HTE #: BRES 2304-0079

HARNETT COUNTY HEALTH DEPARTMENT
ENVIRONMENTAL HEALTH
307 CORNELIUS HARNETT BOULEVARD
LILLINGTON, NC 27546

EXISTING SEPTIC SYSTEM INSPECTION

Purpose of Inspection: 38X18 Inground Pool

POOL PROJECT
UNDERGROUND

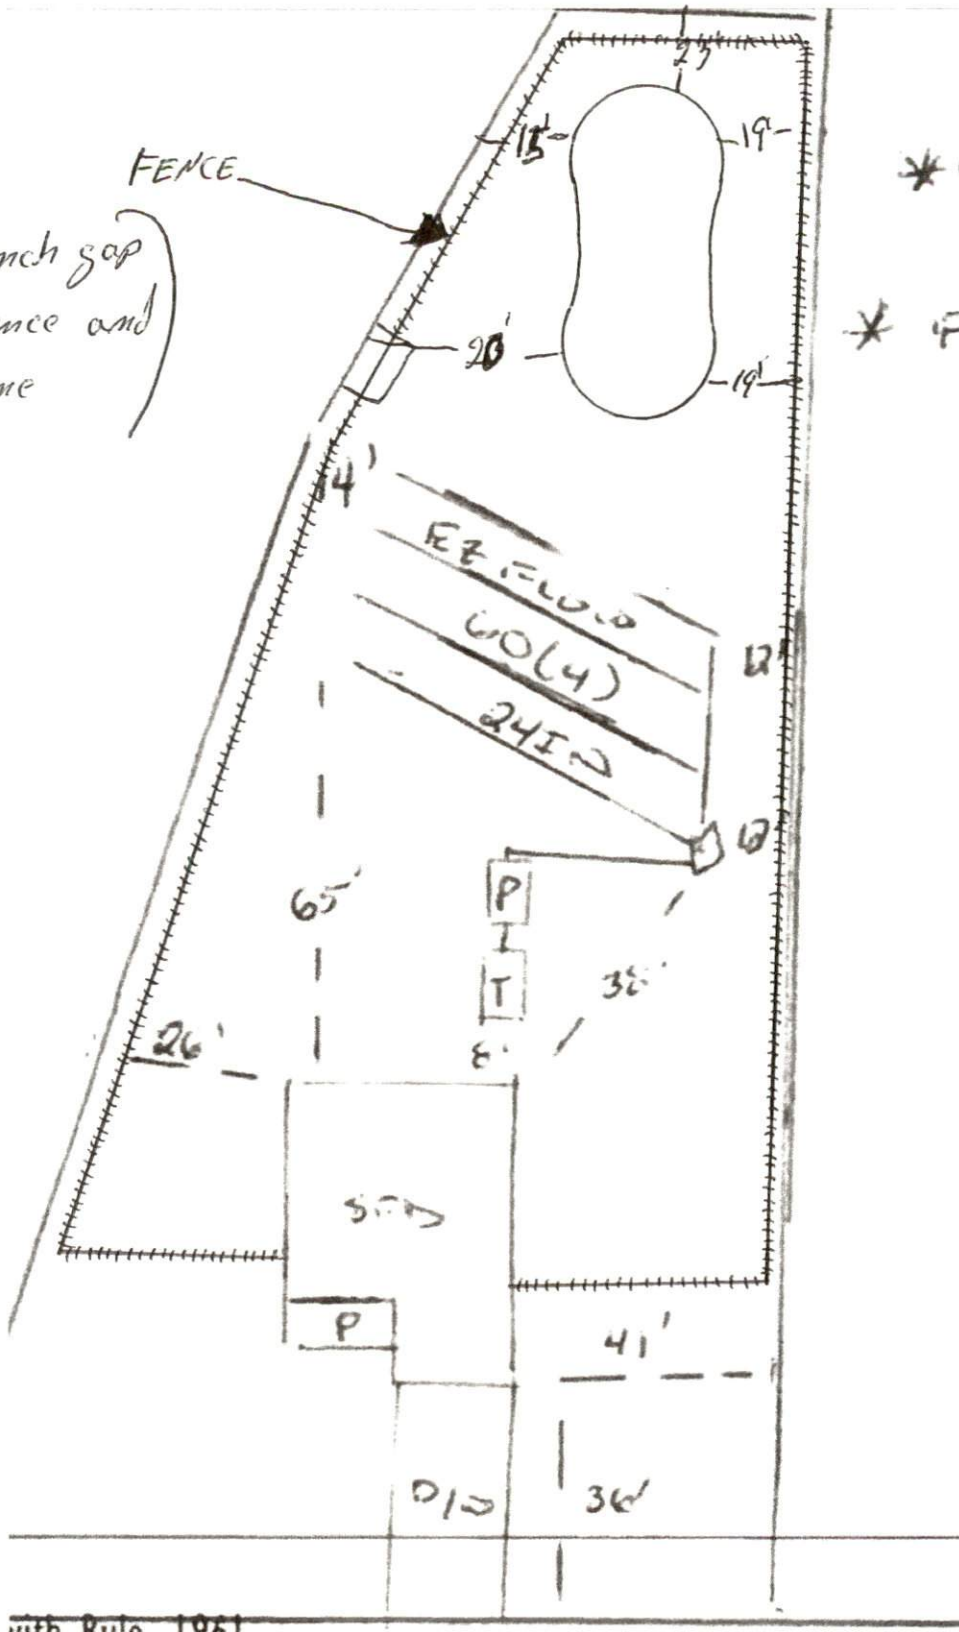
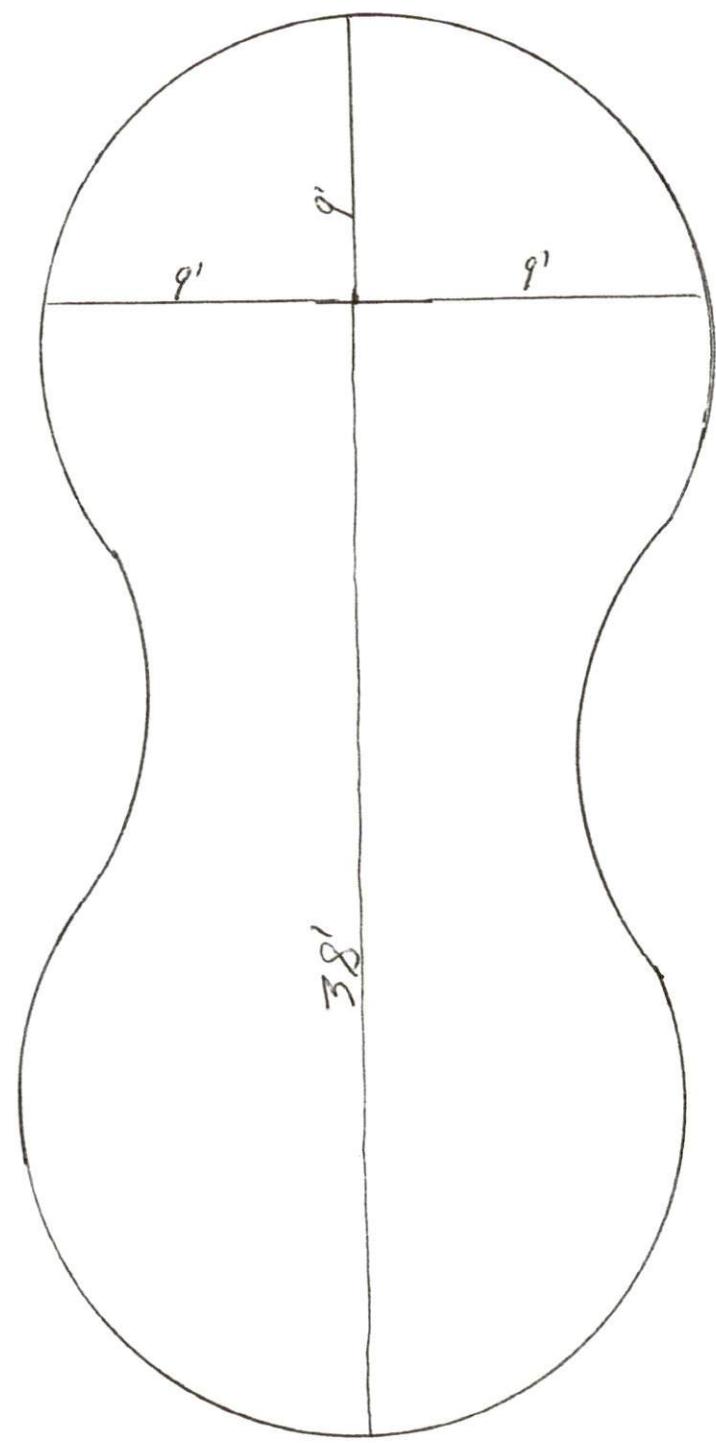
** Spoke with owner about problems that can arise from pool install. * Repair has changed to 50% pool
* Don't drive over septic system*

**BUILDING MUST BE 5' FROM ANY PART OF SEPTIC SYSTEM
DO NOT DRIVE OR PARK ON SEPTIC SYSTEM**
